RE: Addison Galaxy FBO

Attached are the revised plan sheets for the "ASI-C003" revision to the civil plans based on the review comment we received back from the Town last week. We also took this opportunity to reflect that the decision has been made to have steps for the door coming out of the south end of the FBO building, so below is a complete list of the sheets included in ASI-C003 to indicate what, if anything, was changed on each of the sheets since we submitted this revision previously.

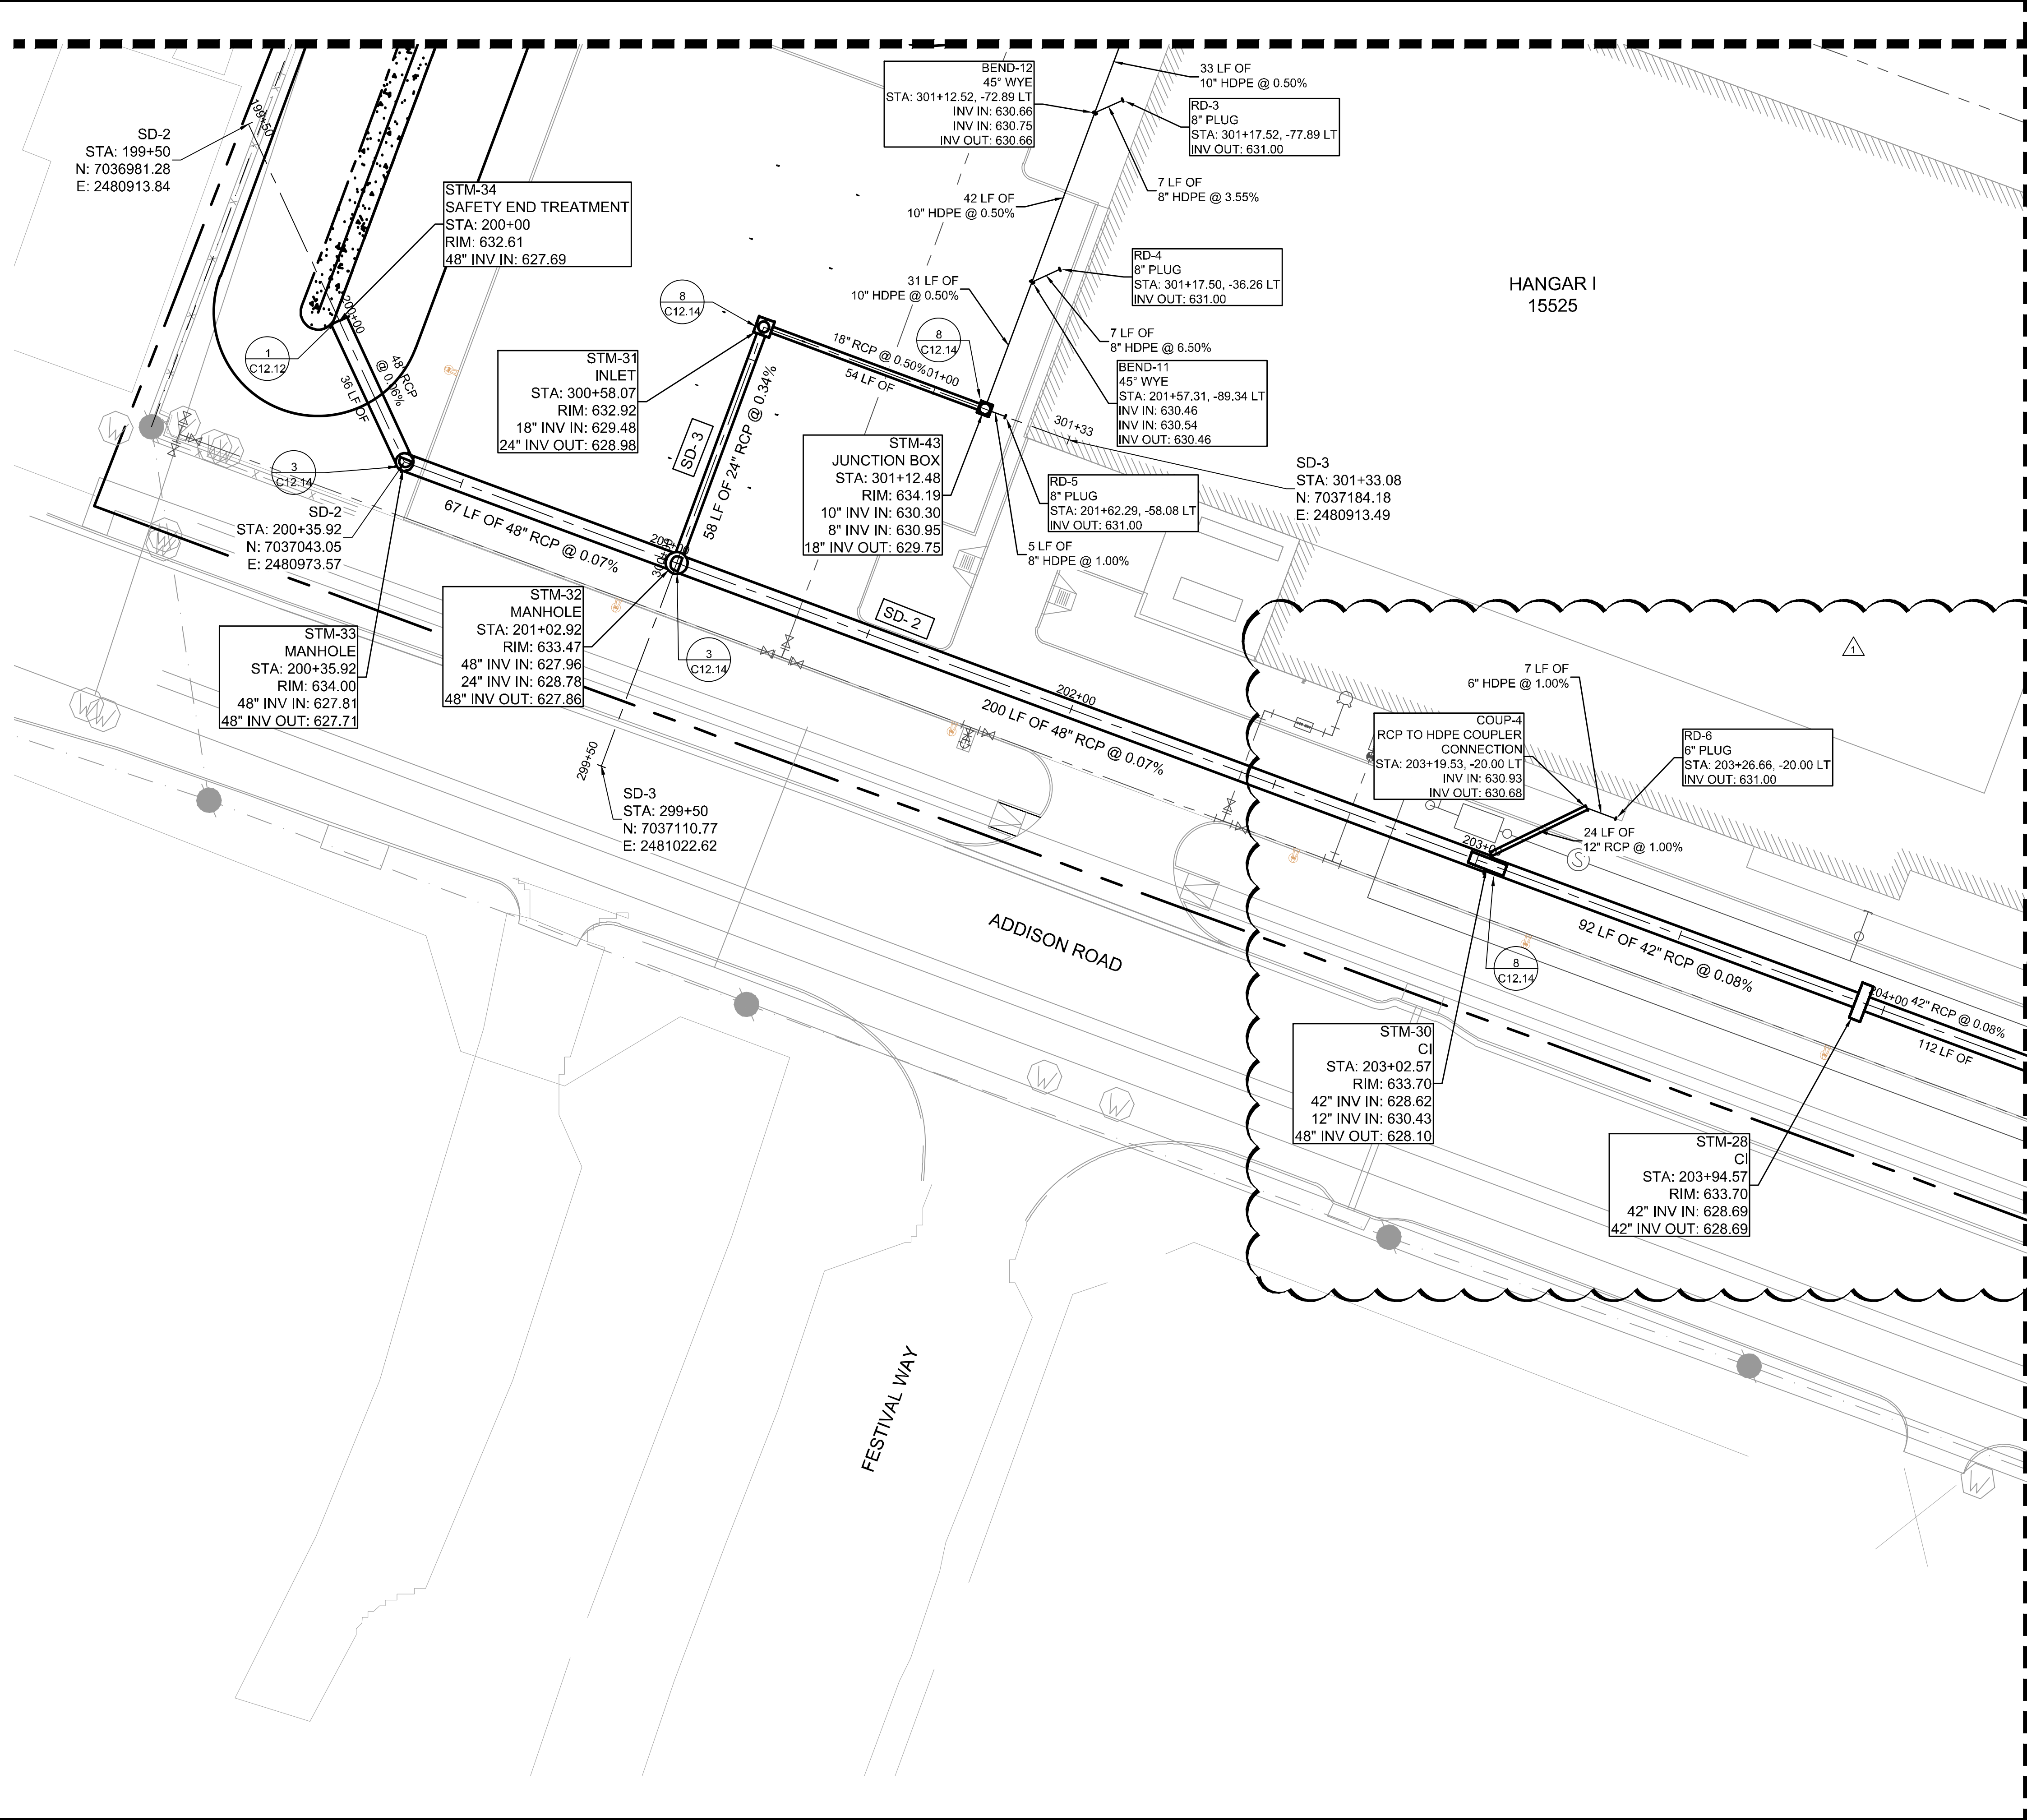
- C10.07 GRADING PLAN – no changes since the original submittal of ASI-C003
- C12.05 STORM DRAINAGE PLAN SD-2 AND 3 – updated the sanitary sewer manhole location to avoid conflict with storm drain

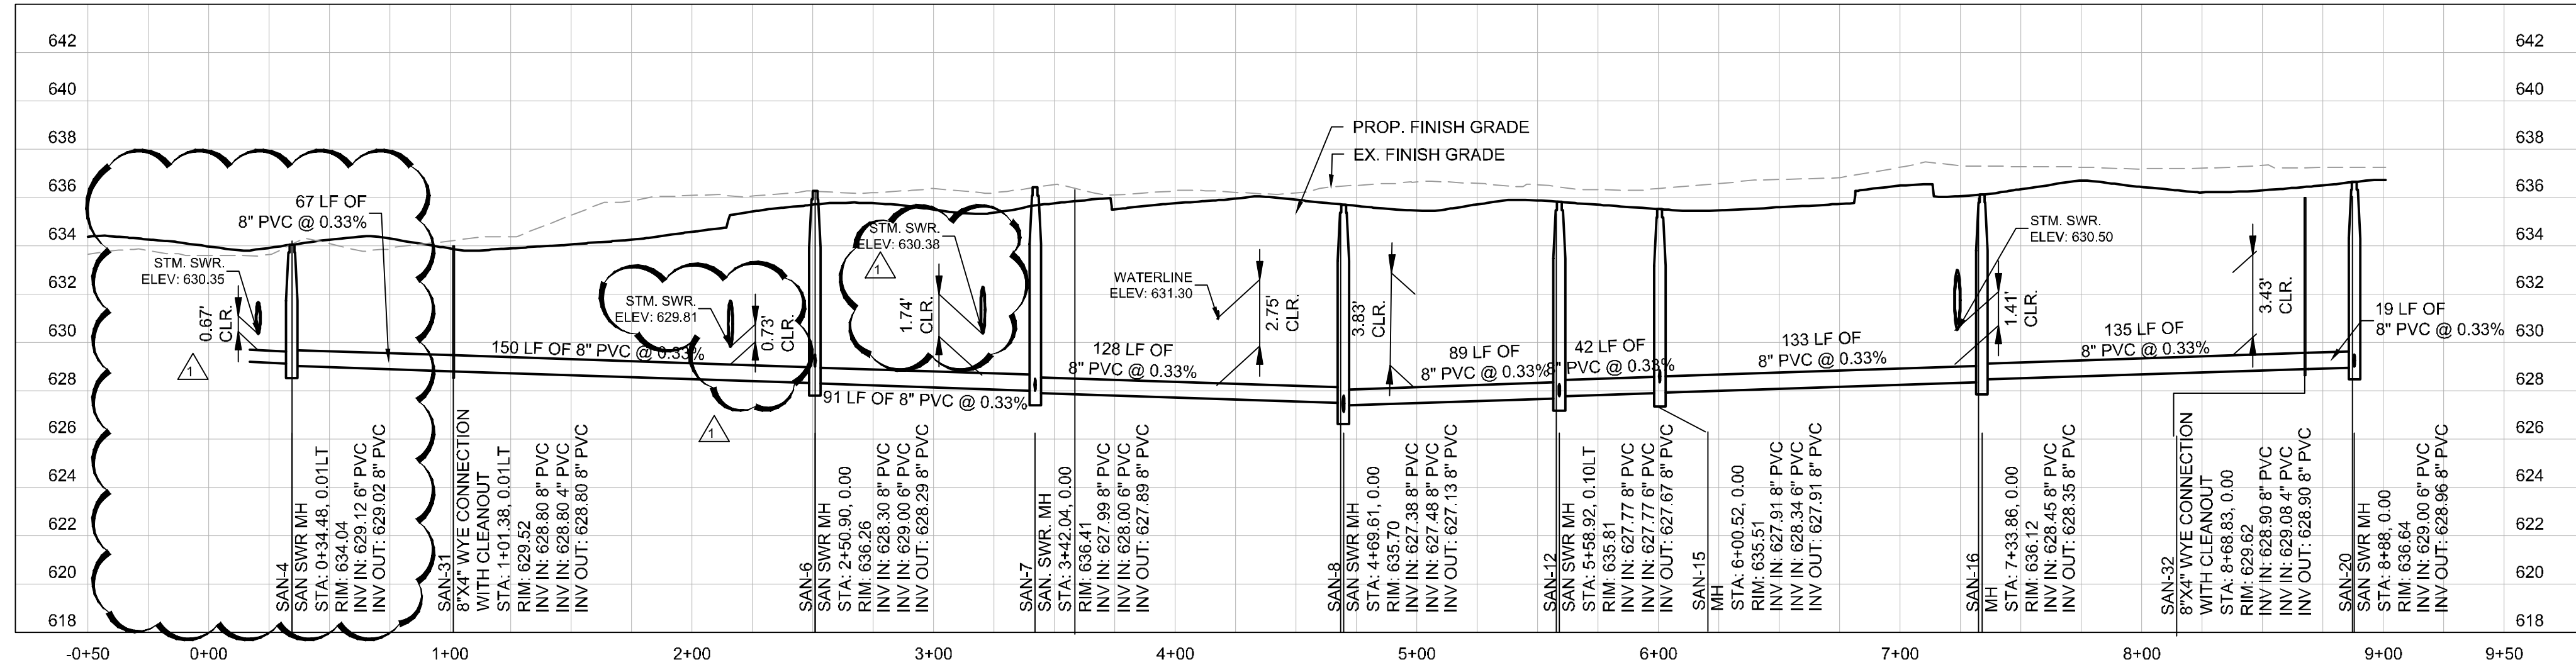
- C13.01 SANITARY SEWER PLAN - updated the sanitary sewer manhole location to avoid conflict with storm drain
- C13.03 SANITARY SEWER PROFILE - updated the sanitary sewer manhole location to avoid conflict with storm drain
